Re: Blake's Lotaburger LLC
3205 Richmond Dr NE Albuquerque NM 87107
Traffic Circulation Layout
Engineer's/Architect's Stamp **04-22-19** (H21D012)

Based upon the information provided in your submittal received 04-25-19, the above referenced plan cannot be approved for Building Permit until the following comments are addressed:

SITE PLAN
JUAN TABO & SNOW HEIGHTS

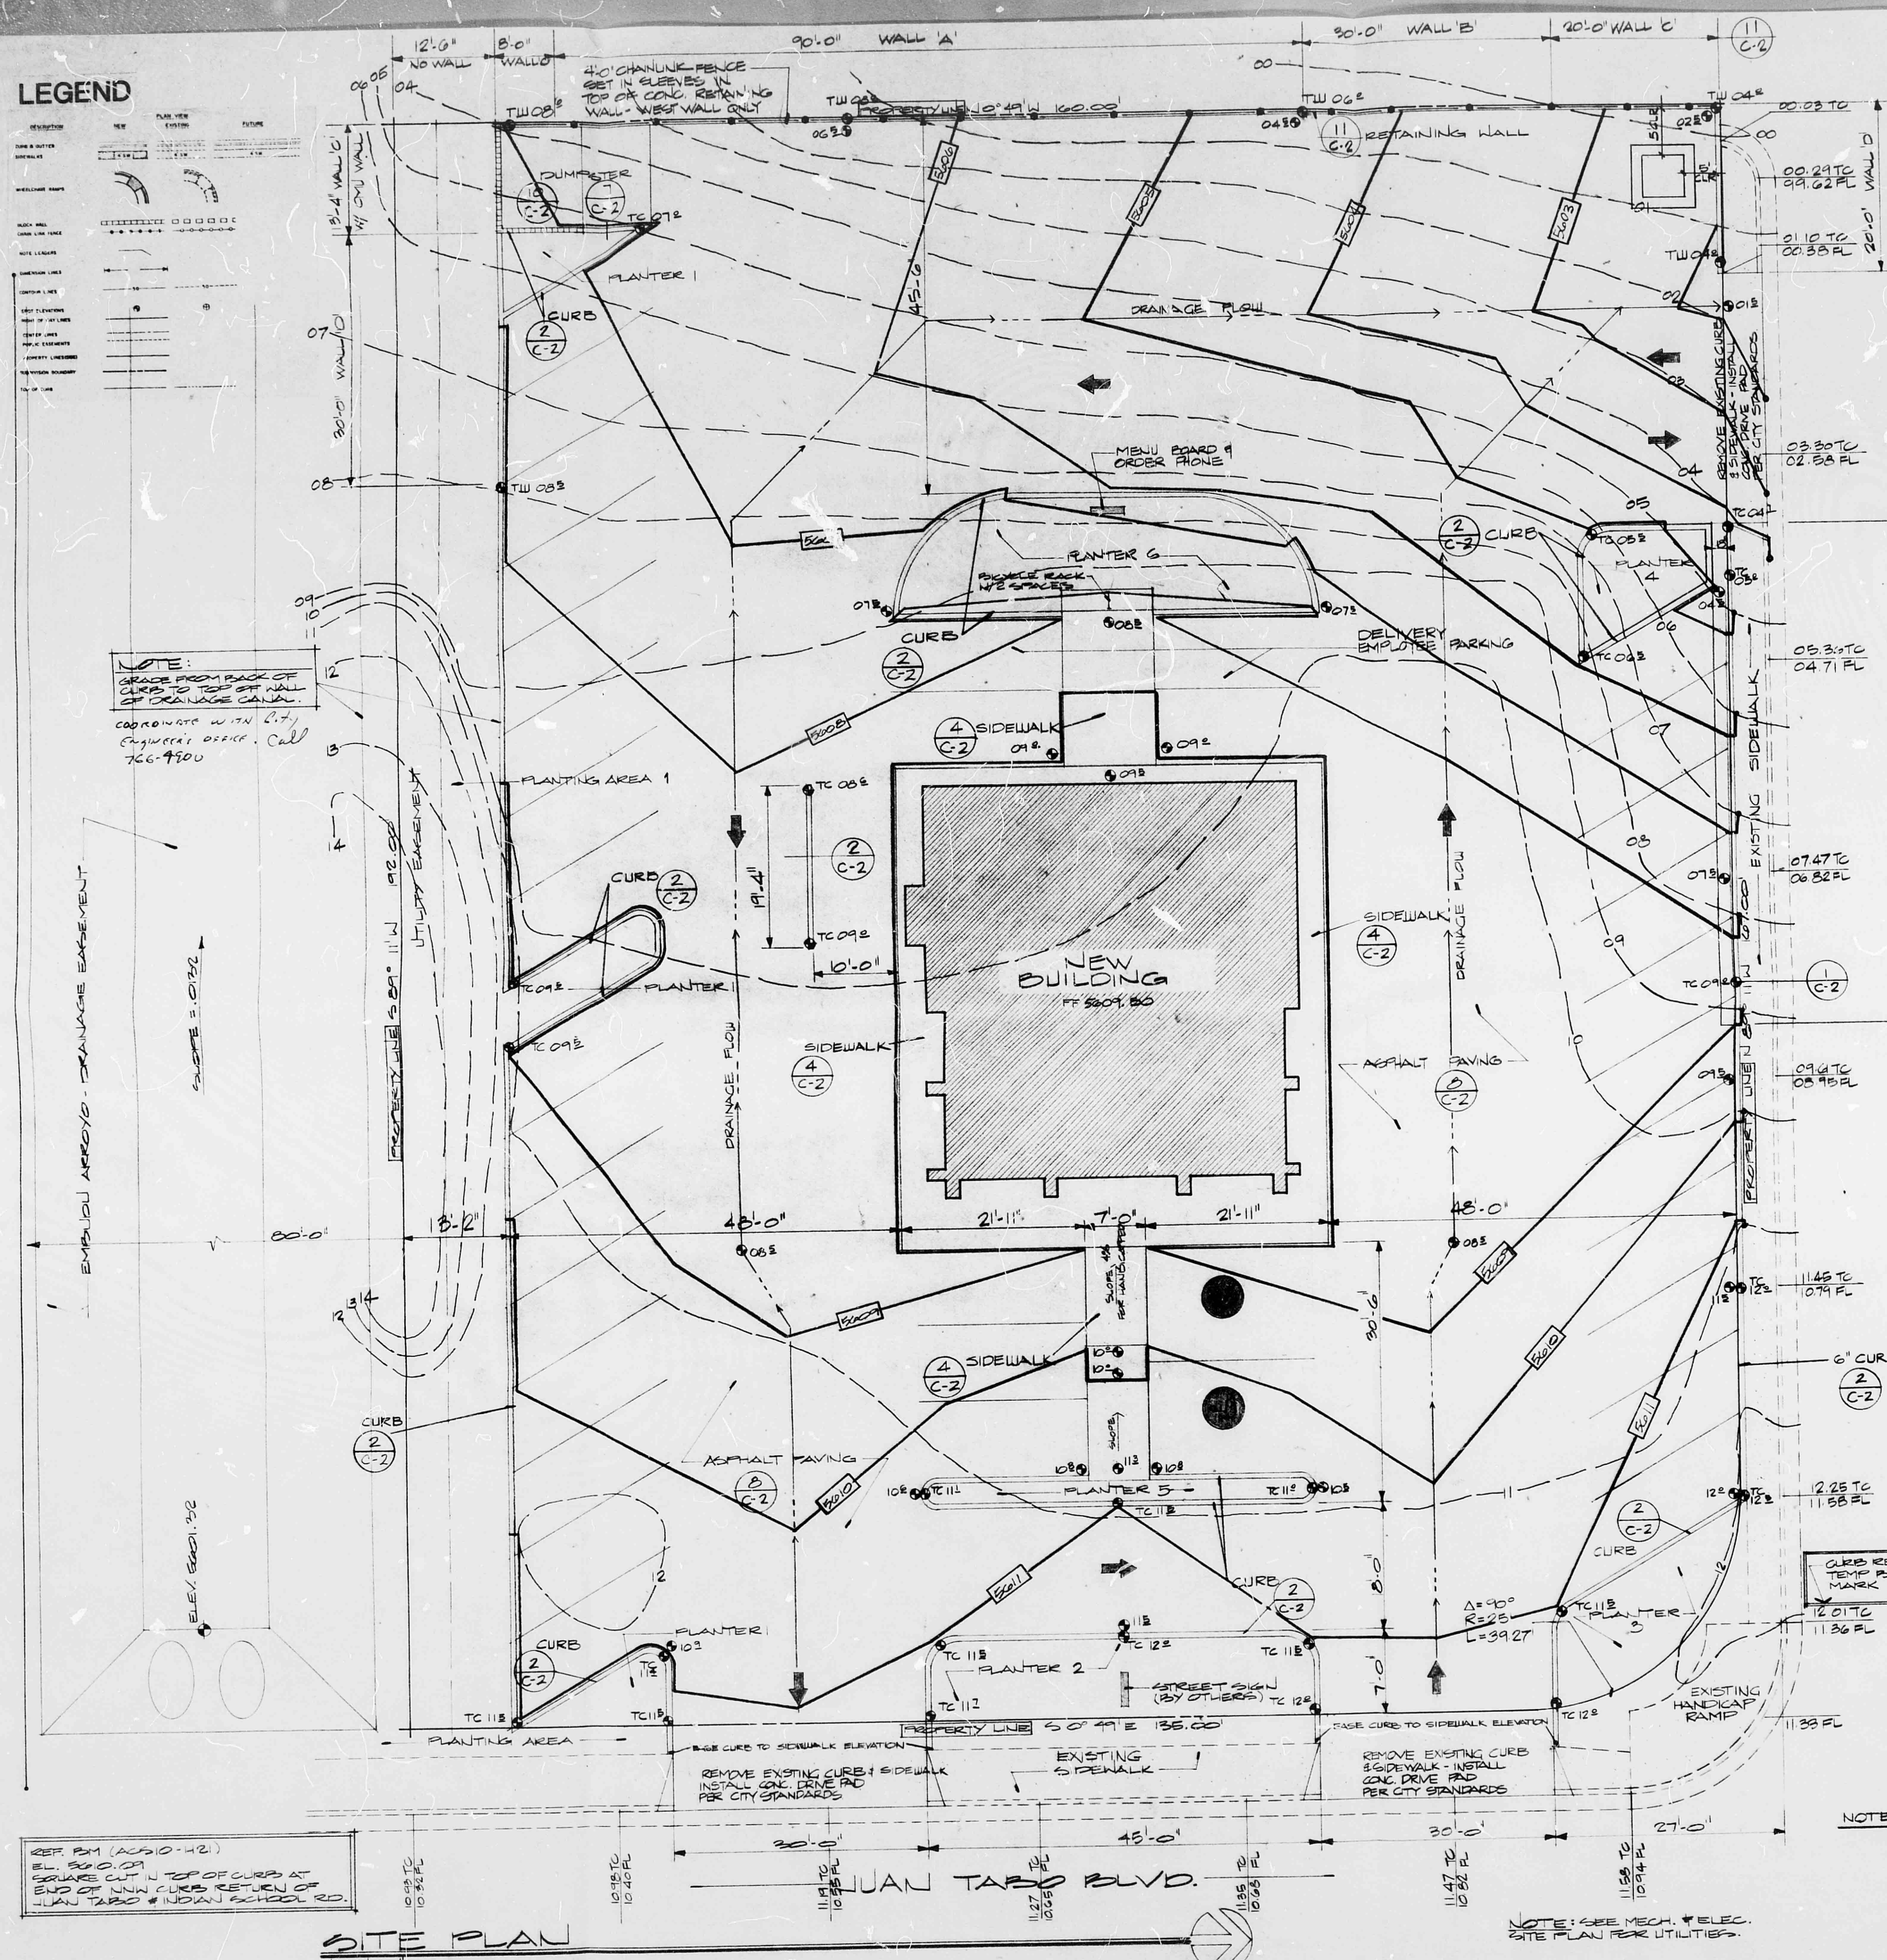
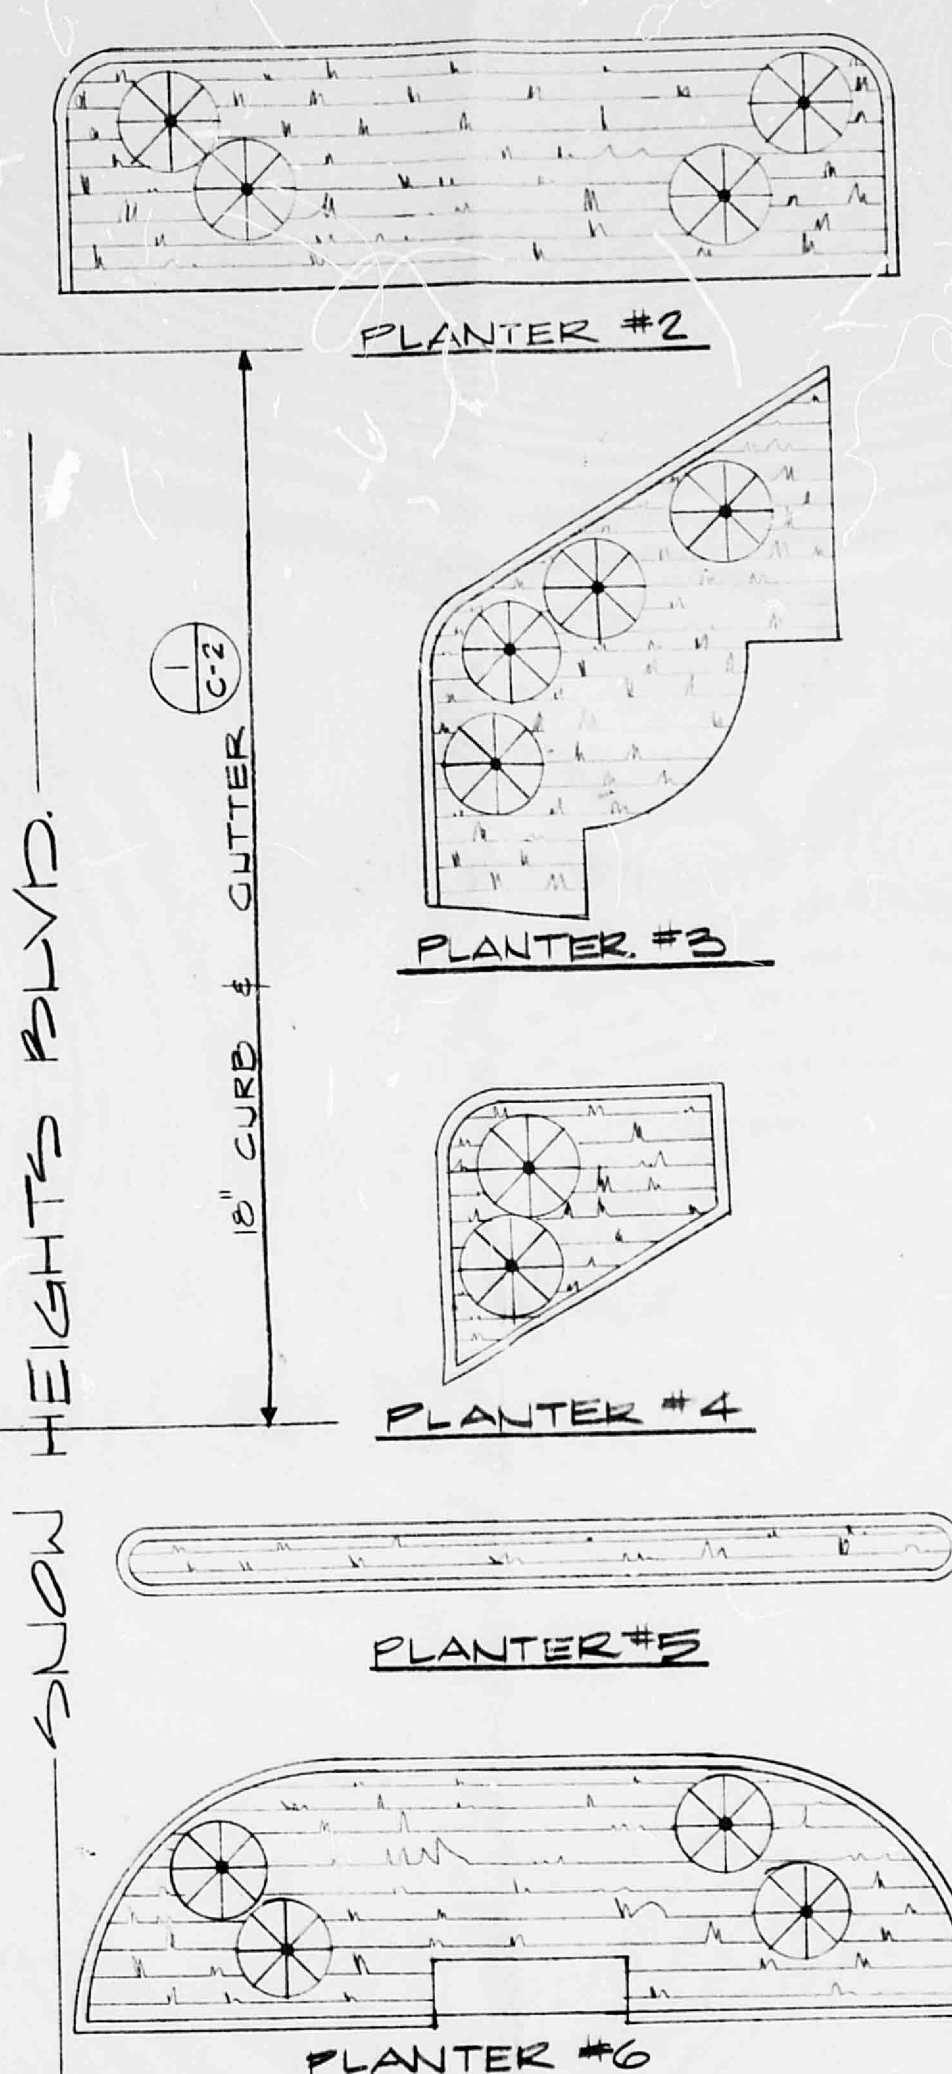
1. The ADA accessible parking sign must have the required language per 66-7-352.4C NMSA 1978 **"Violators Are Subject to a Fine and/or Towing."** Please call out detail and location of HC signs.

2. ADA curb ramps must be updated to current standards and have truncated domes installed.
3. Motorcycle parking spaces shall be designated by its own conspicuously posted upright sign, either free-standing or wall mounted per the zoning code.

4. Per the IDO, a 6 ft. wide ADA accessible pedestrian pathway is required from the public sidewalk to the building entrances. Please clearly show this pathway and provide details.

5. Per DPM, a 6 ft. wide ADA accessible pedestrian pathway is required from the HC parking stall access aisles to the building entrances. Please clearly show this pathway and provide details.

6. ADA accessible pedestrian pathway should not be placed behind parking space or adjacent to a vehicular way. Vehicle and pedestrian/wheel chair conflicts should be avoided as much as possible.

7. **provide a copy of refuse approval.**
8. Unused curb cuts must be replaced with sidewalk and curb & gutter. A build note must be provided referring to the appropriate City Standard drawing.
